**MECKLENBURG COUNTY**  
Park and Recreation Department

MEMORANDUM

**RE:** Rezoning Petition # 2008-073 (PID #s 075-105-43, 075-105-30, 075-105-37, 079-044-02, 075-111-01, 075-124-02, 075-123-01, 075-112-01, 079-043-03, 075-114-23, 075-114-24, and portions of 075-113-04 and 075-113-01.

This is the second correspondence from Mecklenburg County Park and Recreation Department (MCPR) regarding rezoning petition #2008-073. These comments are based on the second submittal of plans dated May 15, 2008. We suggest that these comments be incorporated into the Planning Commission staff review notes and written into the Pre-Hearing Staff Analysis to the fullest extent possible. These steps should ensure MCPR's notes are conveyed to and incorporated by the petitioner during plan revision.

**Technical Plan
Petition #2008-73**

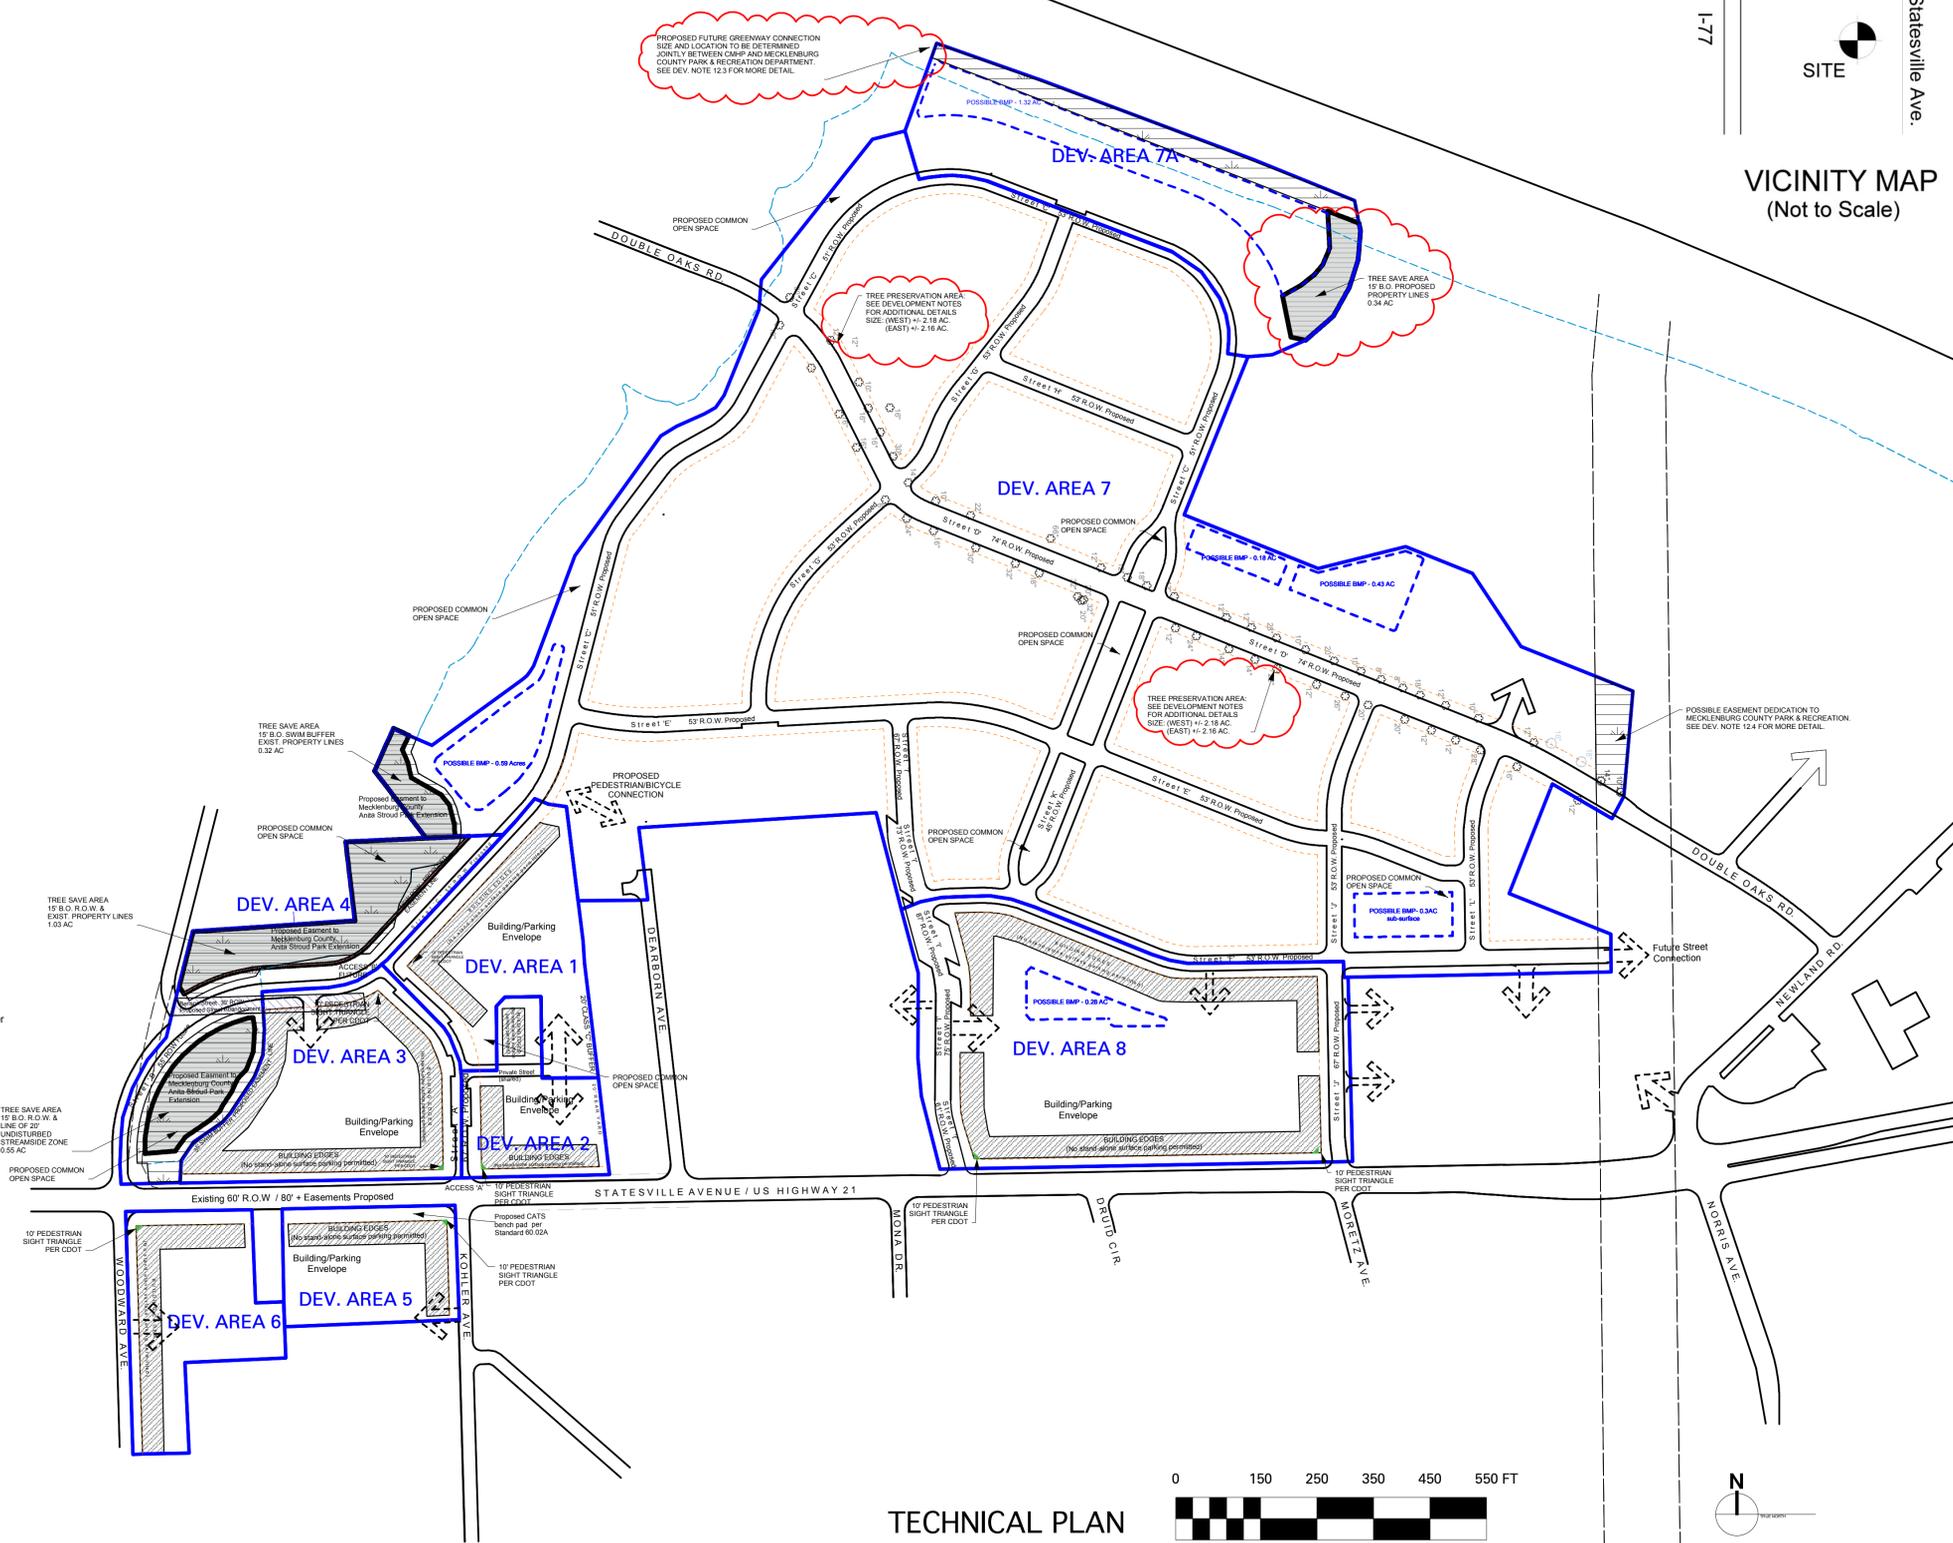
MCPR has discussed the proposed minimum 30' easement to the east of the I-77 wall, as addressed in item 12.3 of the Development Notes sheet. MCPR encourages the petitioner to position the BMP in another location that does not impact the future greenway. All BMPs should be located outside of the areas to be dedicated to MCPR.

MCPR requests that the word “possible” be removed from the note “Possible easement dedication to Mecklenburg County Park & Recreation. See Development Note 12.4 for more detail” as written on the Technical Plan. MCPR recognizes that much of the requested easement is outside of the area included in this rezoning. However, the easement should be recognized on the site plans pertaining to this rezoning, delineated in the area between County property (PID# 075-123-02) and Double Oaks Rd. as depicted in the Schematic Plan, and identified in future rezonings involving the property underlying the Duke Energy right-of-way. Additionally, MCPR requests that a mid-block crossing be installed at the center of the easement where it crosses Double Oaks Rd. The Duke right-of-way represents an important east-west overland greenway connector that will link together Irwin Creek Greenway and Little Sugar Creek Greenway.

MCPR recognizes and appreciates the petitioner’s “proposed easement to Mecklenburg County” as illustrated in the Technical Plan in between the eastern end of Anita Stroud Park and Development Area 4 of RP# 2008-035. This will allow for a pedestrian connection from Statesville Ave. through easements dedicated during RP# 2008-035 to Anita Stroud Park and the future Irwin Creek Greenway. As shown in the Technical Plan for RP# 2008-073, no BMP should encroach on the easement area to be dedicated to MCPR.

Note 12 on the Development Notes sheet refers to “Conveyance of Easement for Greenway Purposes”. This note should state the conditions of dedications (both fee simple and easements) regarding this particular rezoning, with conveyance to occur prior to the issuance of the first certificate of occupancy for the first unit within the area encompassed by this rezoning. Furthermore, no roads should be dedicated within areas to be conveyed to MCPR.
